Subject: RE: Planning Consultation on: LU/163/20/PL

Please see comments below from Private Sector Housing.

Application No: LU/163/20/PL

Registered: 2nd July 2020
Site Address: 6 Selborne Place Selborne Road Littlehampton BN17 5NH
Grid Reference: 503276 101647
Description of Works: Demolition of existing conservatory, single storey front & rear extensions & change of use from HMO (Sui Generis) to 5 No. flats (4 net) (C3 Dwelling house). This application affects the character & appearance of the Littlehampton Seafront Conservation Area & may affect the setting of a listed building. This application is not CIL Liable as flats in Zone 4 (Zero Rated).

drawing title
Proposed Plans
-
PLANNING

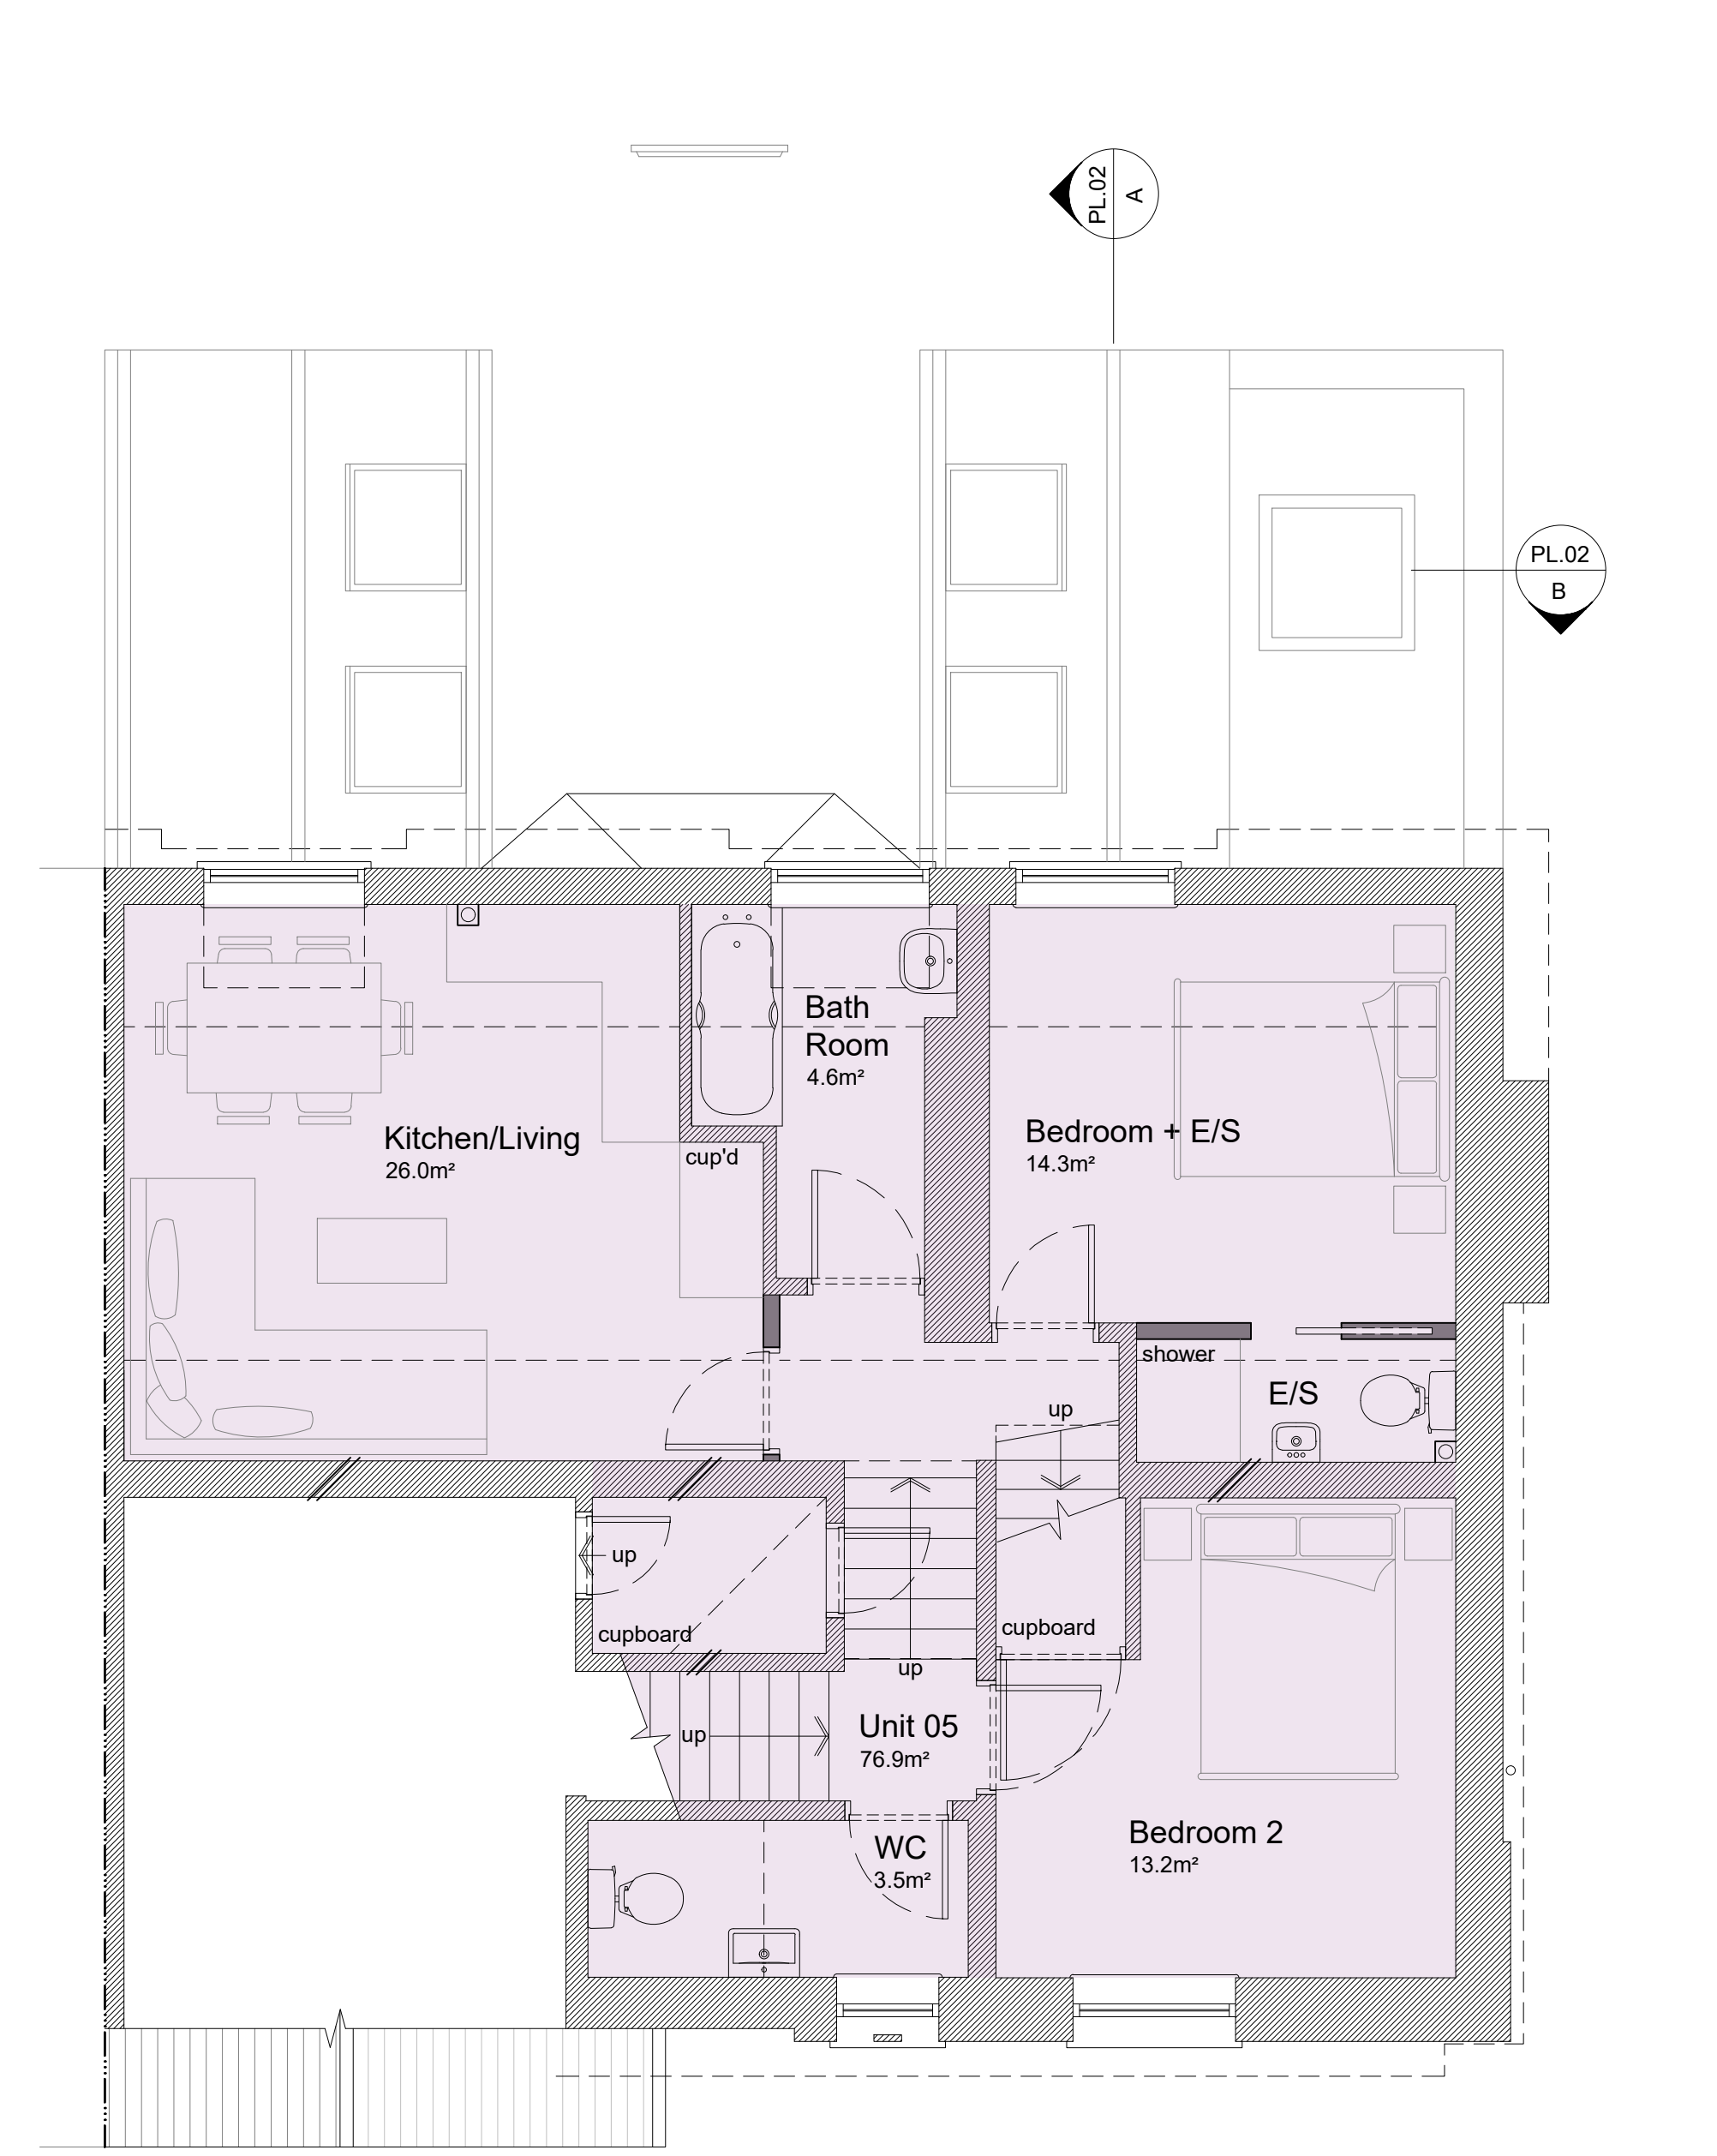
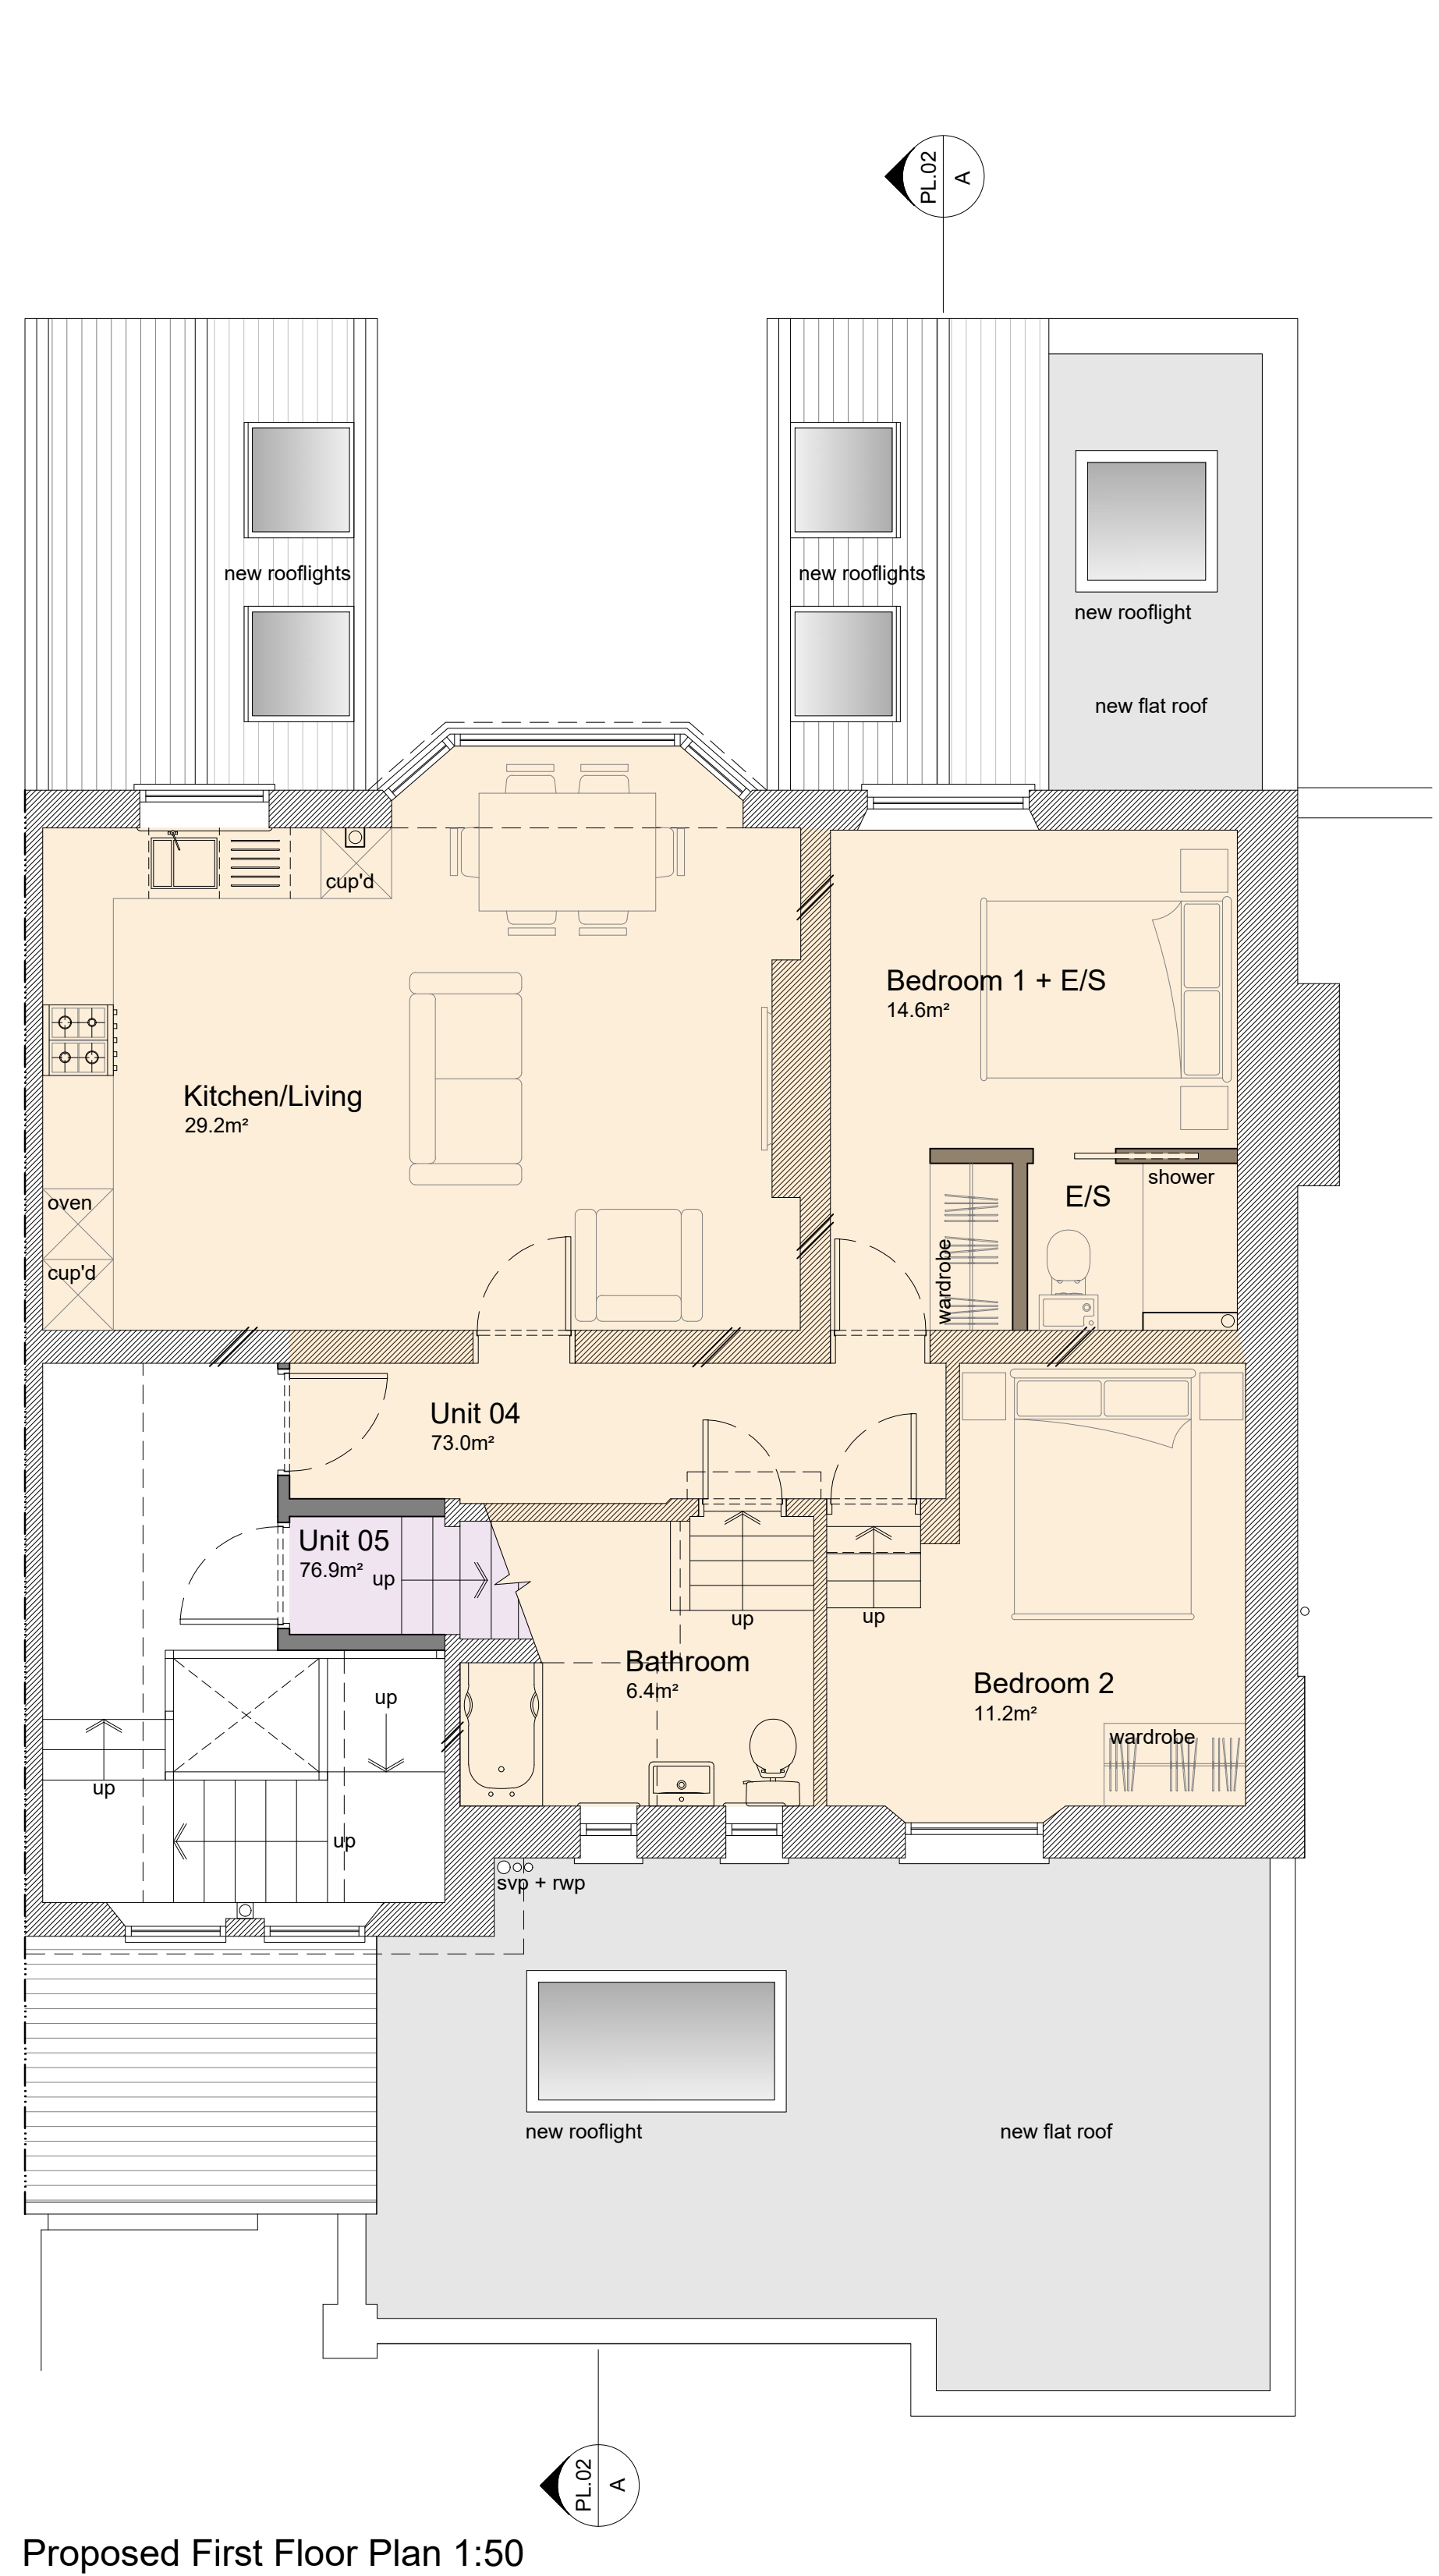
- A room where the only escape route is through another room is termed an “inner room” and poses a risk to its occupiers if a fire starts unnoticed in the outer room. The escape route from the bedroom in Unit 02 is via the kitchen; this can be overcome by ensuring that the window in the bedroom is an escape window and there is adequate fire protection within the flat. However, an escape window should only be installed if the following criteria can be met:

- The window should lead to a place of ultimate safety
- 30 minute fire resisting escape route should be provided, including 30 minute fire resisting and self-closing fire doors (FD30S) to Units 01, 04 & 05 (Units 02 & 03 have their own private entrance) and electrics to be enclosed in fire resisting compartment

- There appears to be part of a staircase above the kitchen in Unit 03. If this is indicating the steps in the bathroom in Unit 04 above, then no other action is required. However, if the stairs are in relation to an escape route, the underside of the staircase within Unit 03 will need to be underdrawn to ensure it affords 30 minutes fire resistance

- Kitchens should have adequate mechanical ventilation
- Mechanical extraction should be provided to all bathrooms/shower rooms/en suites
